From: Borg Belinda <bborg@penrithcity.nsw.gov.au>
Sent: Tuesday, 1 July 2014 9:06 AM
To: Pascal Van De Walle
Subject: Re: Email from Department of Planning in relation to TNT Section 96 (MOD2) - SSD-6040 at Lot 201 DP 1133...

We have reviewed the information and note the following amendments to the approved architectural plans:

DRAWING TITLE  
**ELEVATIONS- GATEHOUSE & TRUCK WASH**

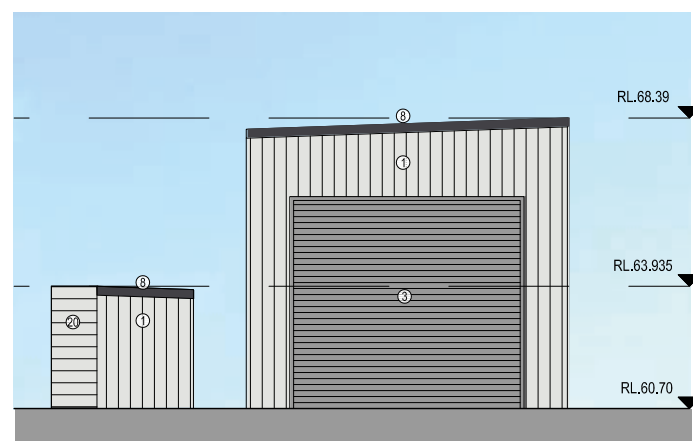
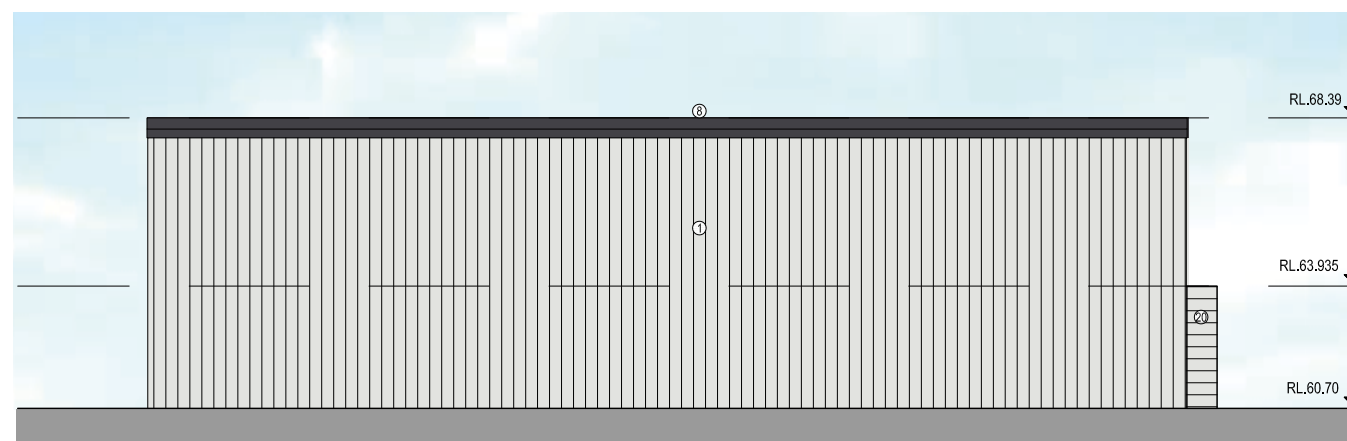
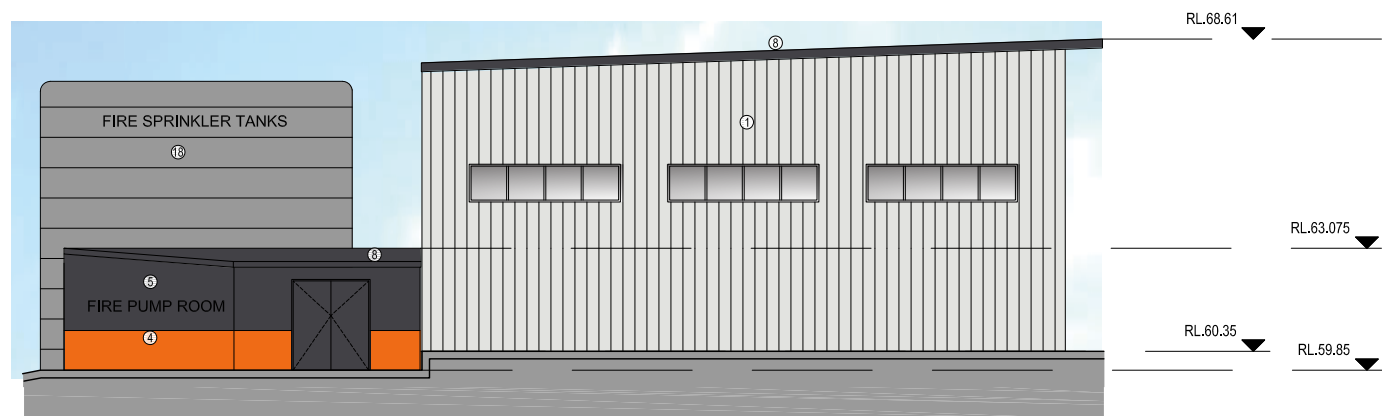
We also note that the location of the truck wash would impact on the useability of the loading docks within grids 23 – 26, however smaller trucks could be used within the

The architectural features included within the main building, such as the use of oversize rainwater pipes, orange panels etc have not been replicated within the truck wash or truck maintenance buildings. The use of one colour is a poor design option.

Council raises no other objection, subject to a little more architectural detail to the truck wash and maintenance buildings.
